CITY OF ALBUQUERQUE

September 4, 2024

**RE: Ideal Vacuum
5920 Midway Park Blvd. NE
Grading and Drainage Plan
Engineer's Stamp Date: 08/23/24
Hydrology File: E17D041D**

# OVERALL GRADING PLAN

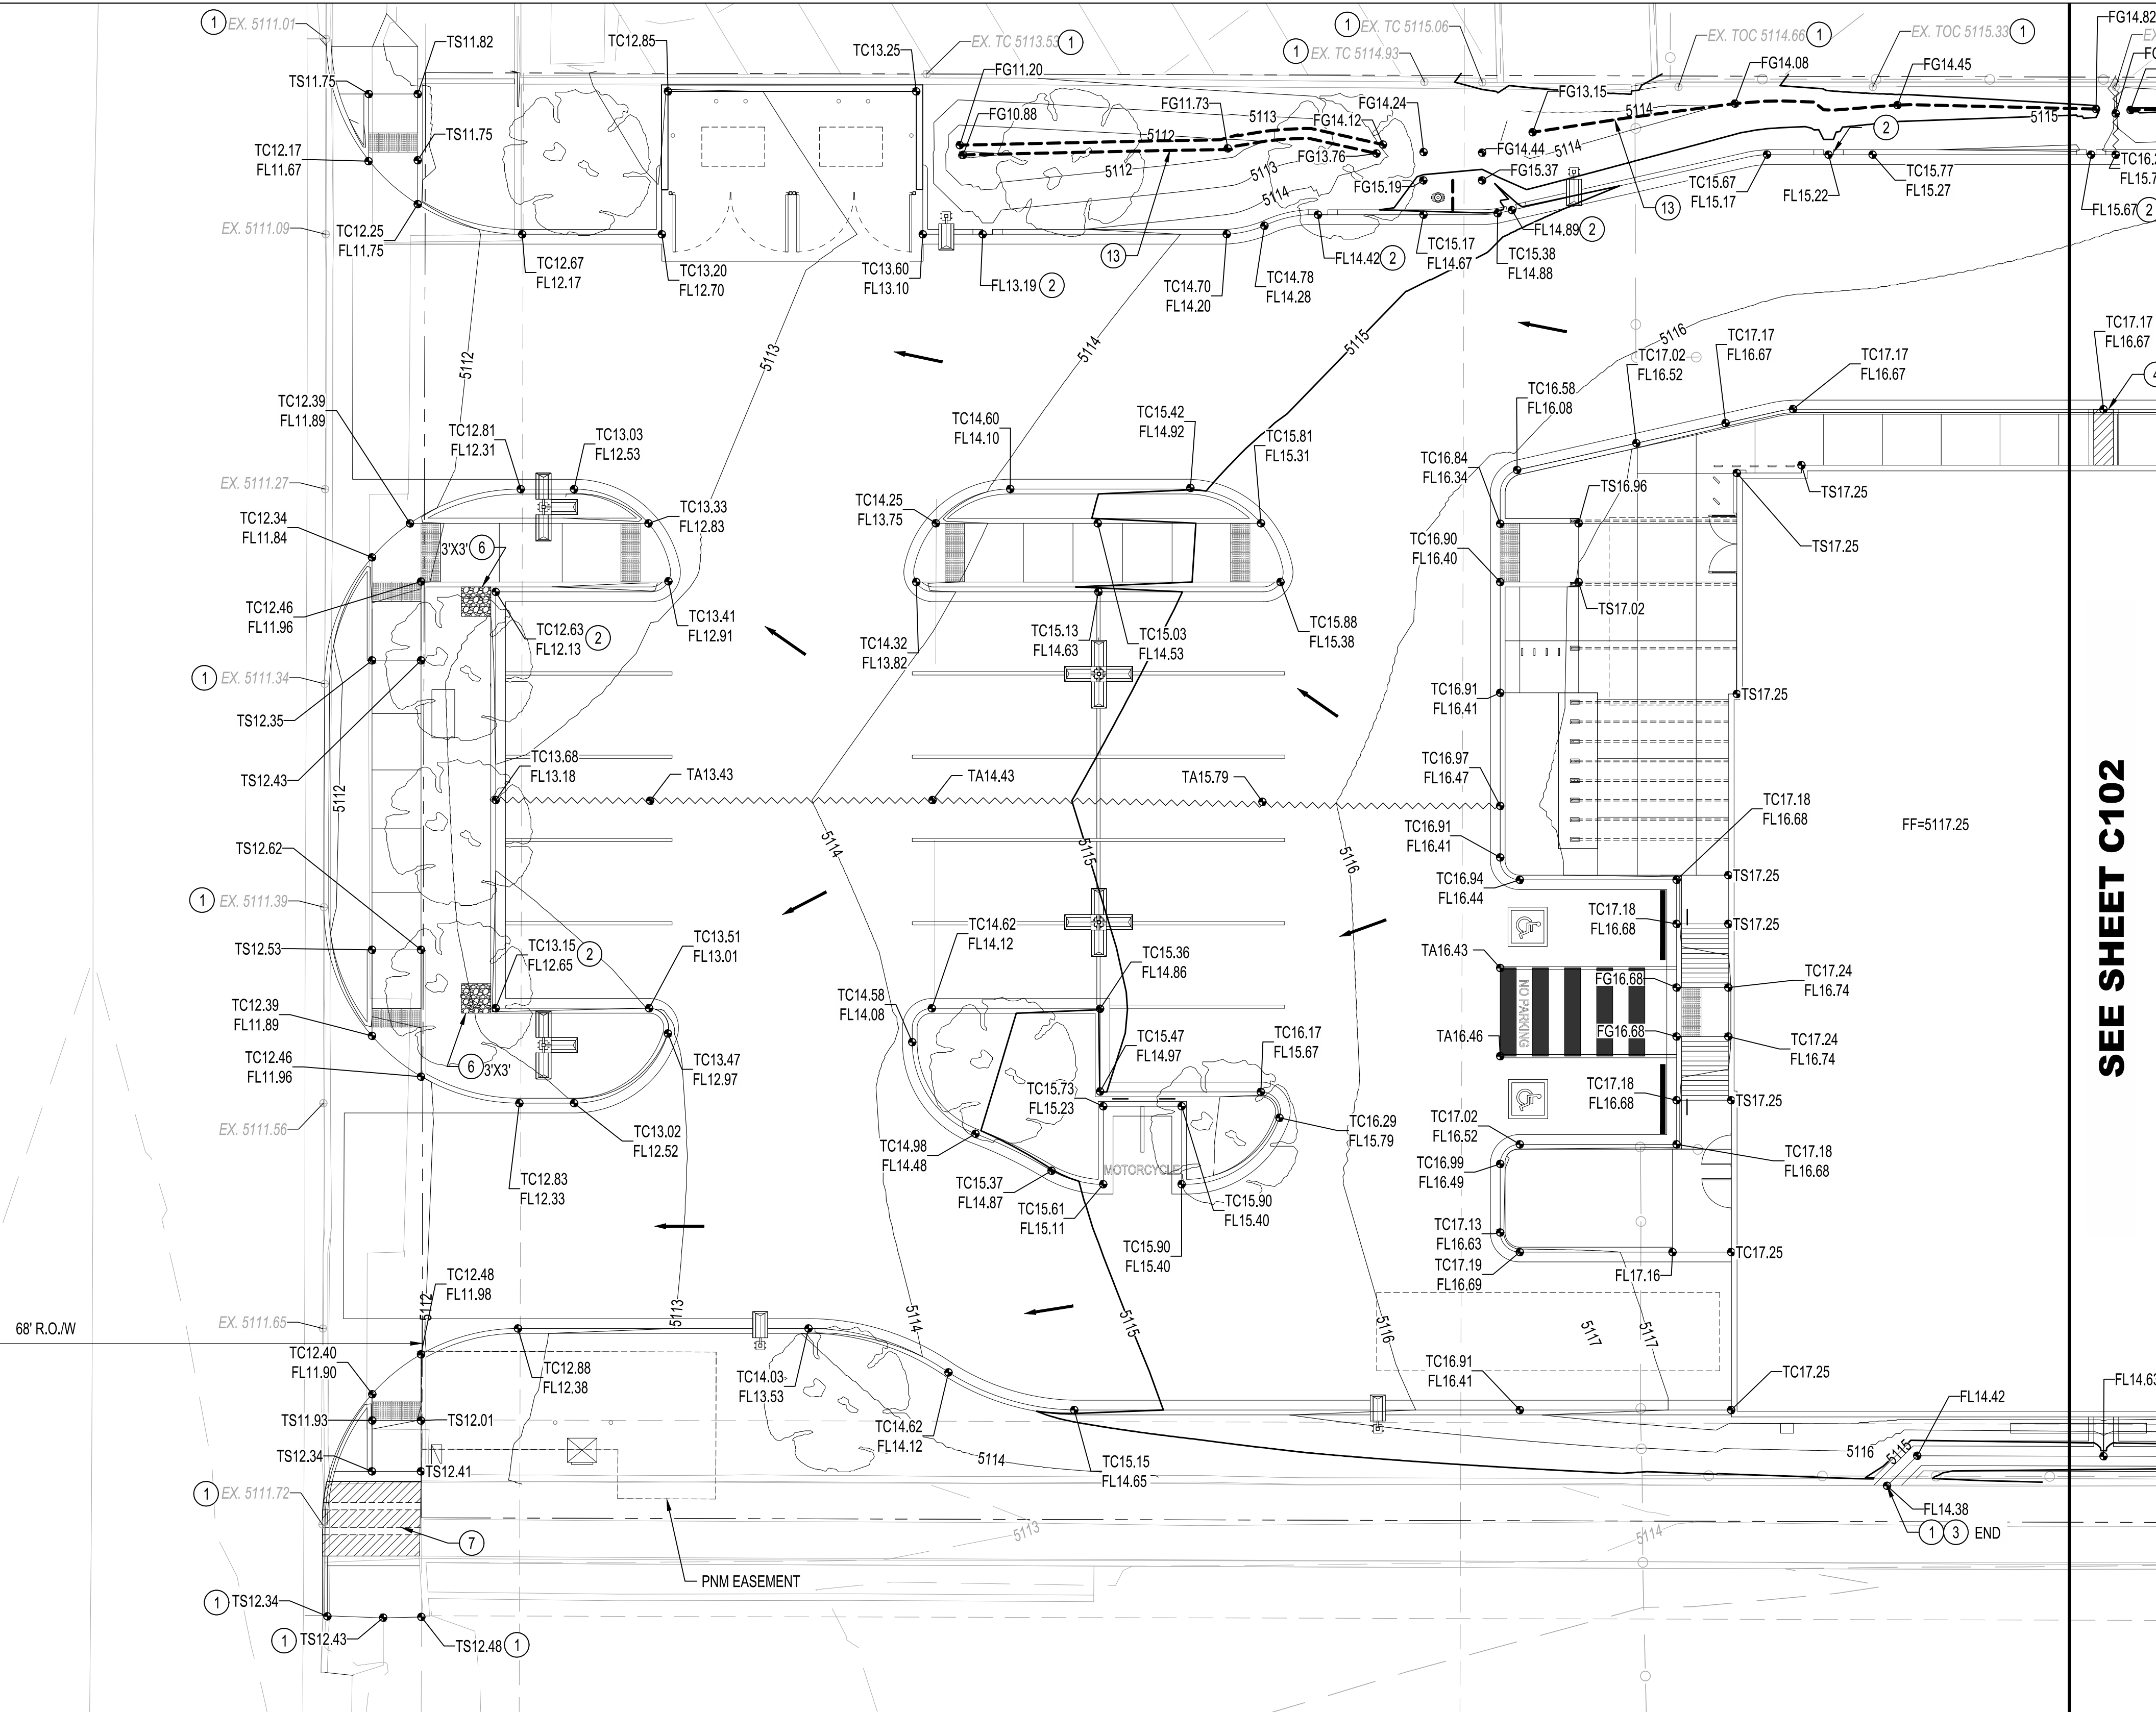
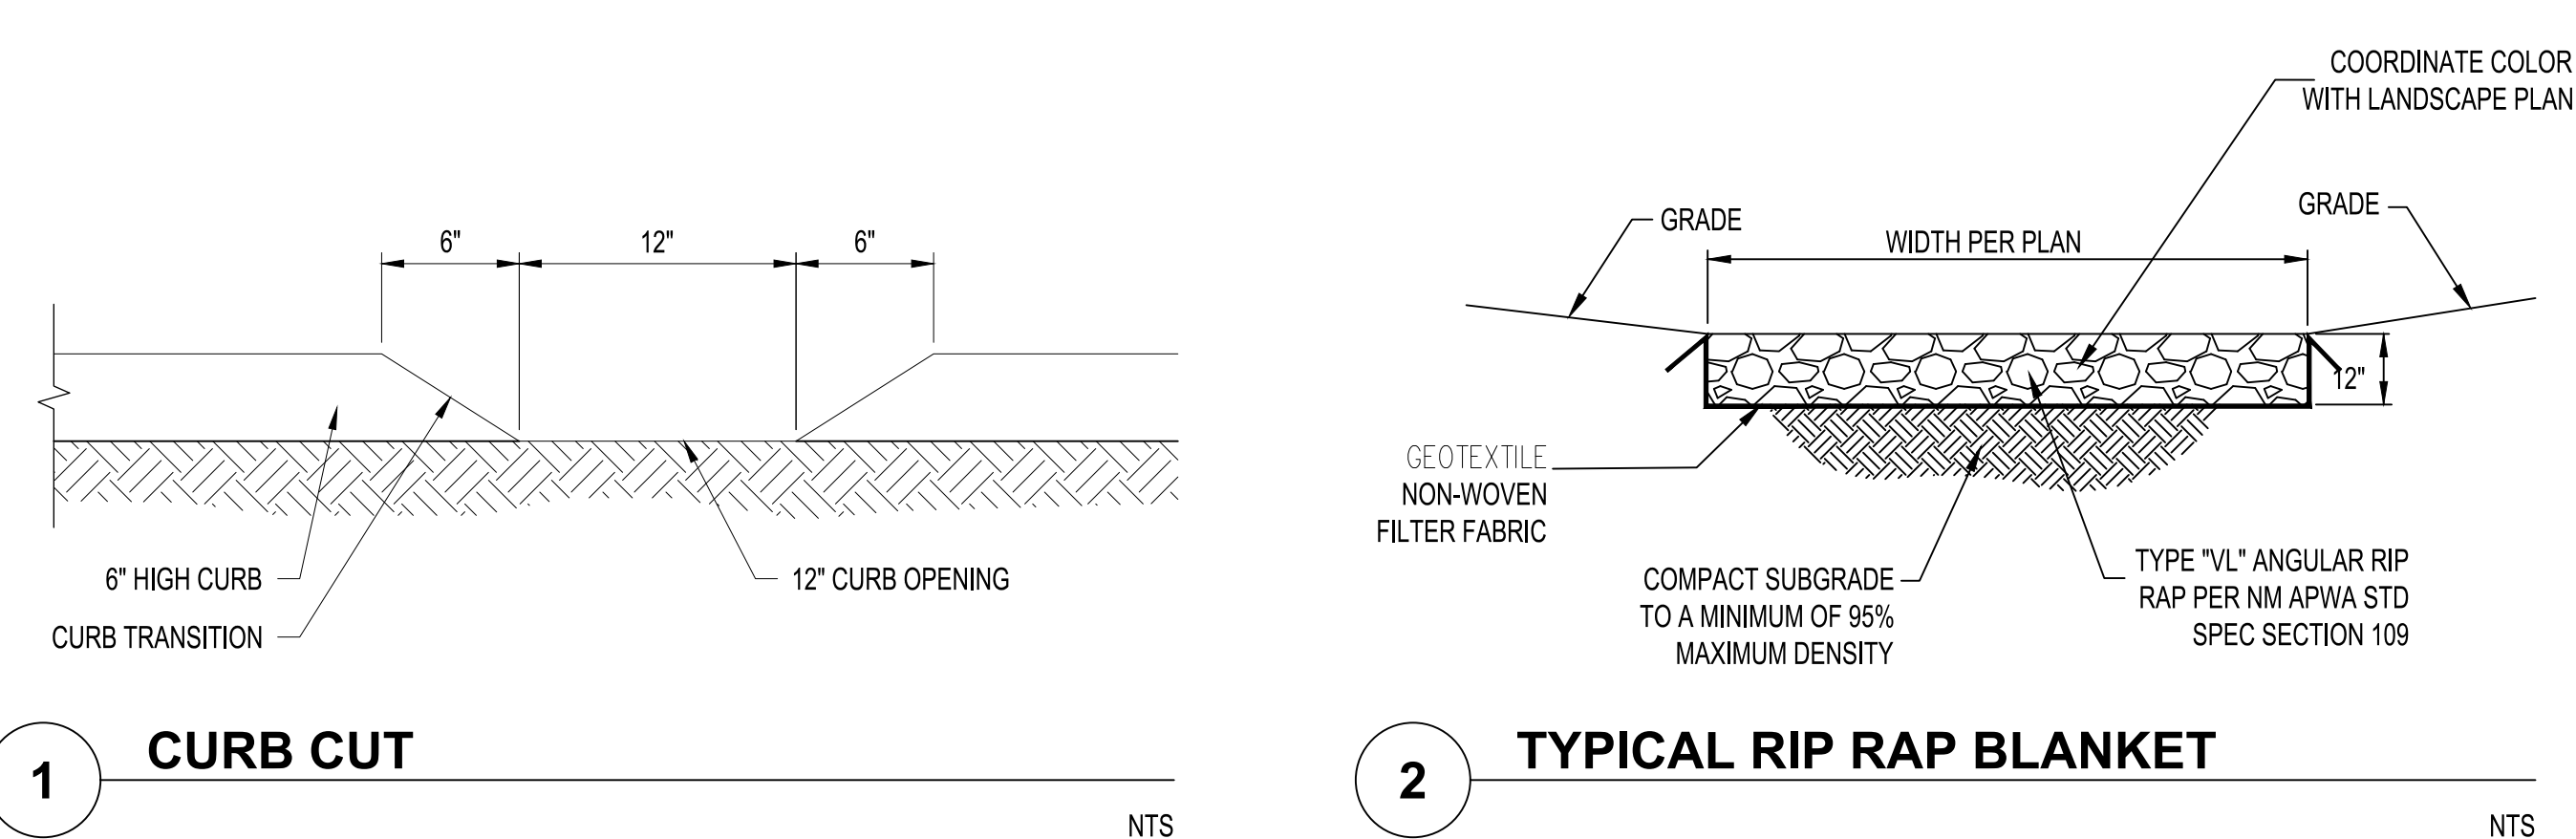
1. The Land Treatment Percentages in the Existing Basin Data Table exceed 100%.
2. Add the Retaining Wall Detail to the plan.
3. Provide the existing and proposed grades on both sides of the proposed retaining wall.

## GRADING PLAN

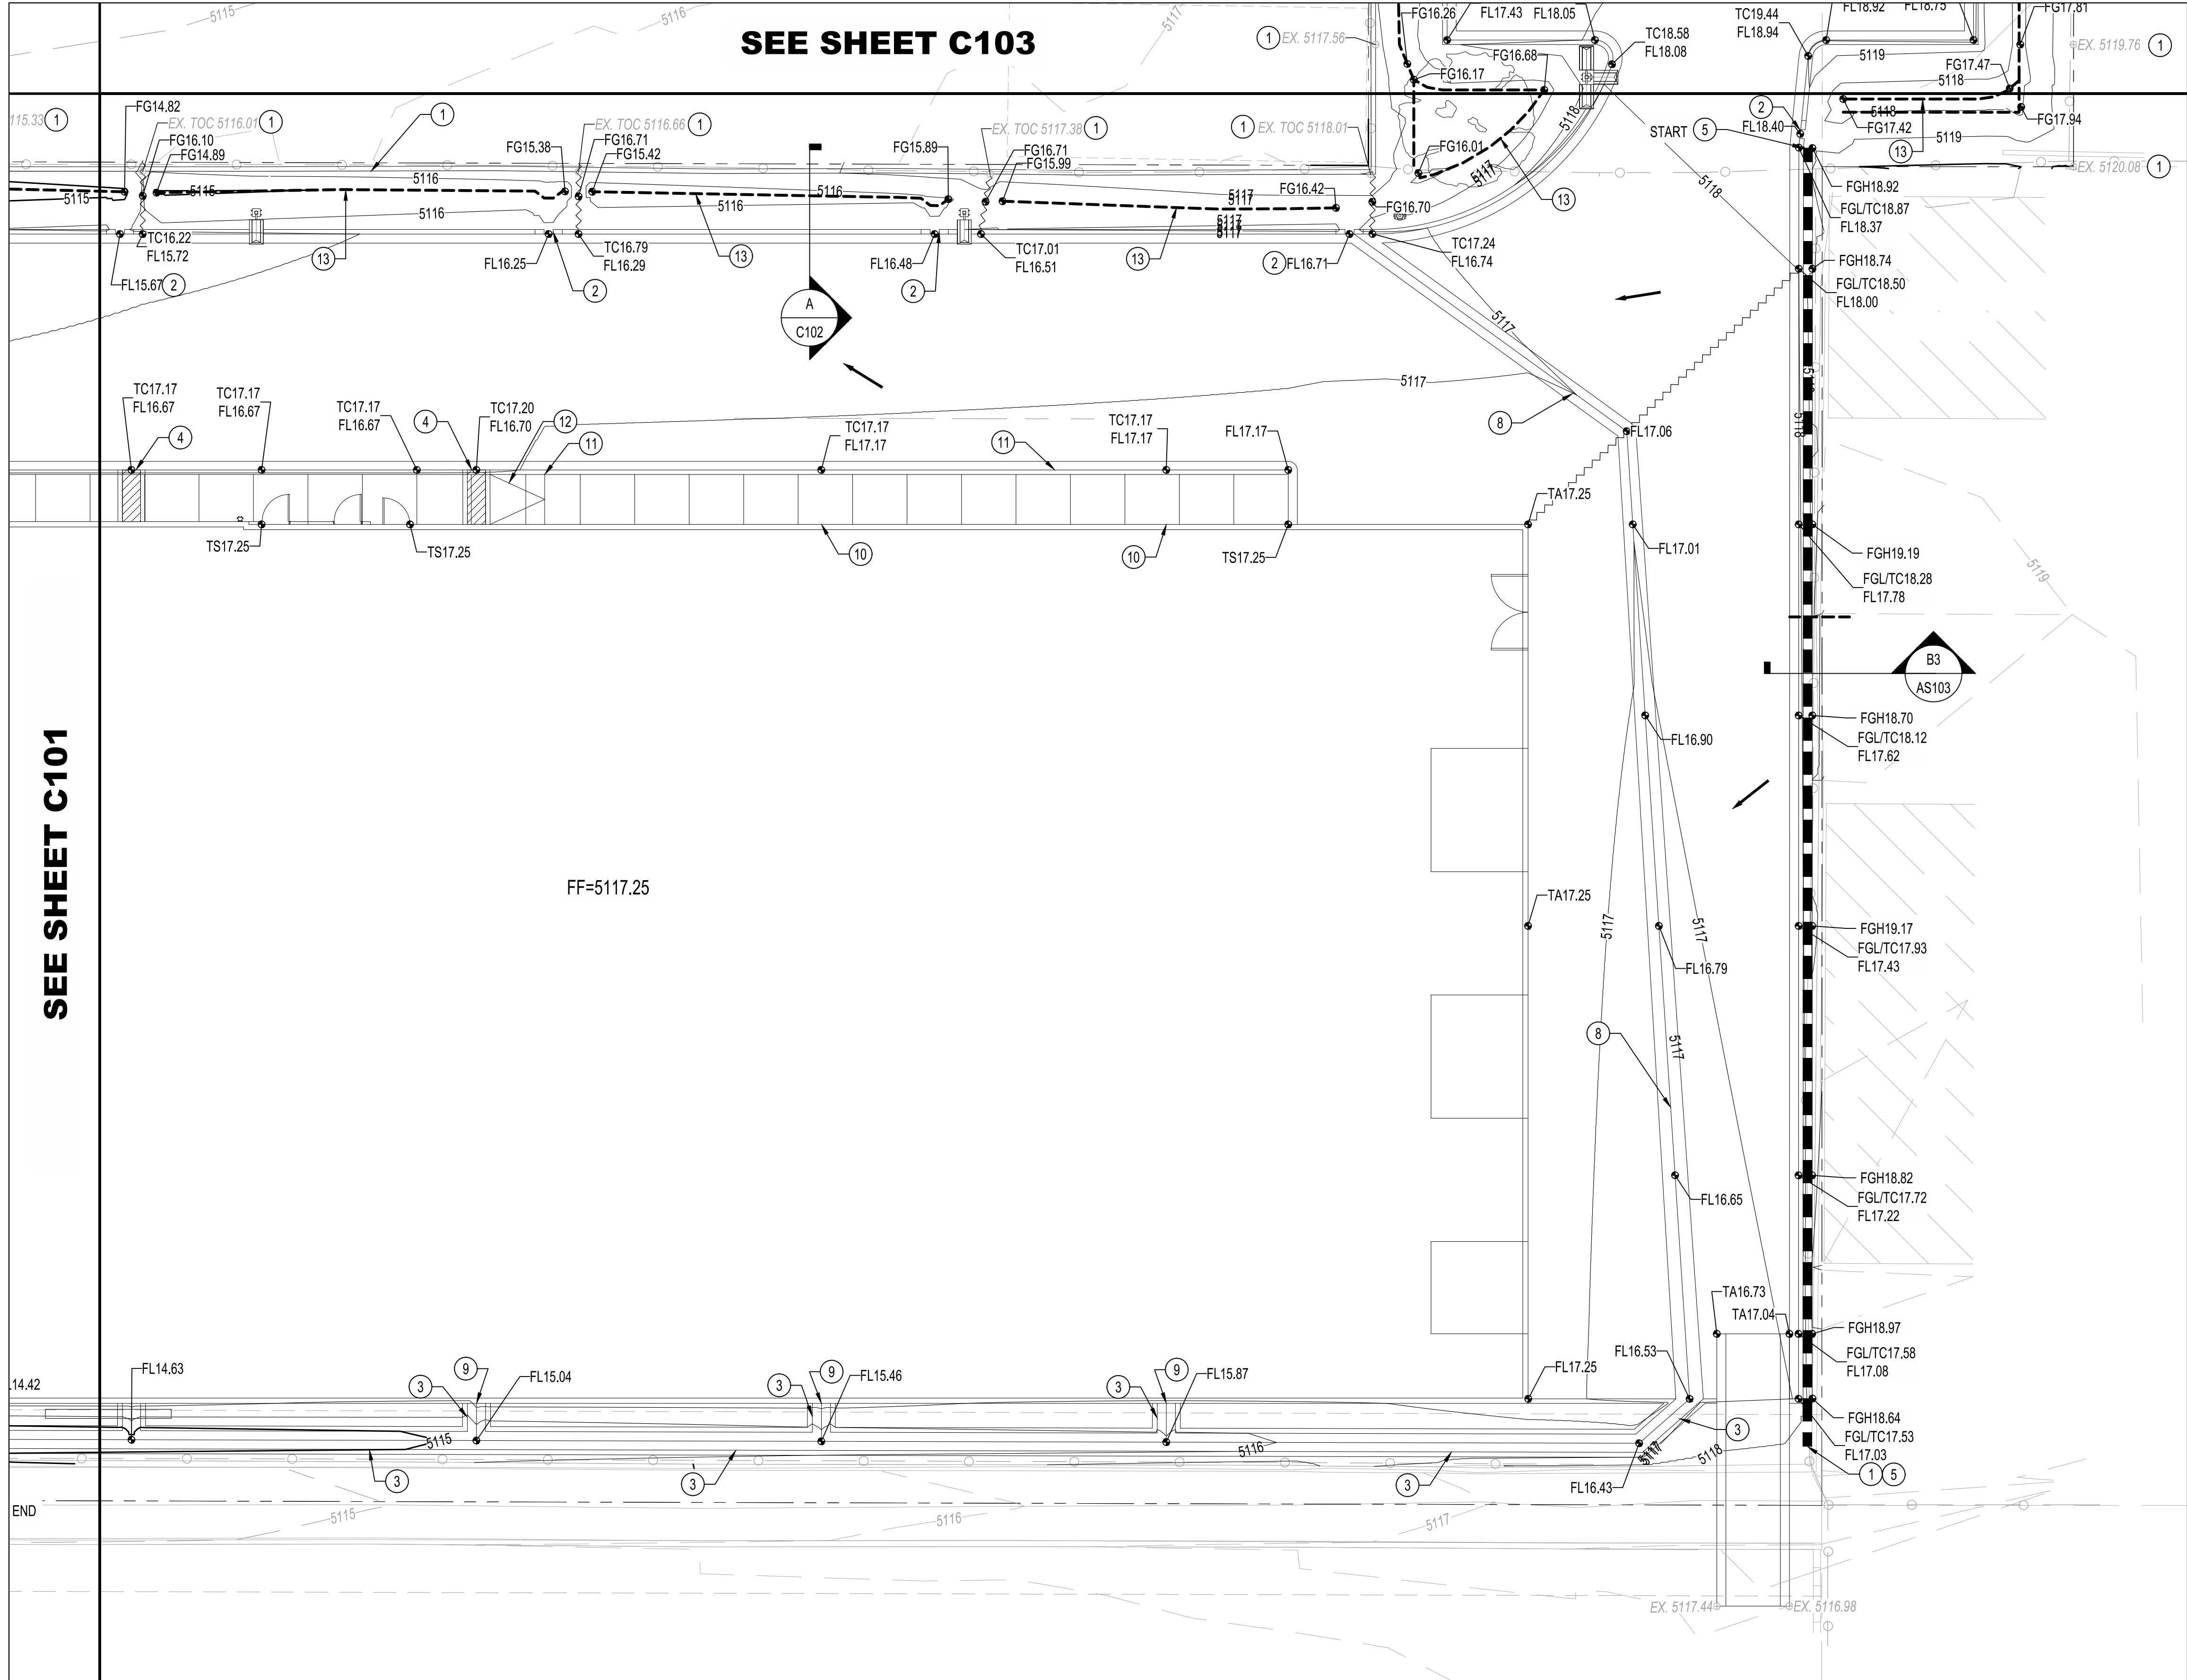
4. Provide sections through all external boundaries showing proposed retaining walls, garden walls, property/ROW lines, existing and proposed grades. In accordance with DPM Ch.22, section 5 part B, grading and wall construction near the property line may not endanger adjacent property or constrain its use.

7. Please add the drainage arrows for site.
8. Please show the Stormwater Quality volume provided within each pond along with the water surface elevation of the SWQ volume in a chart.

9. Please number the ponds and include a label on each with the SWQV and elevation, the 100-year volume and elevation, the peak 100 year inflow and outflow, the spillway crest elevation, the spillway flow depth, and the dam top elevation.
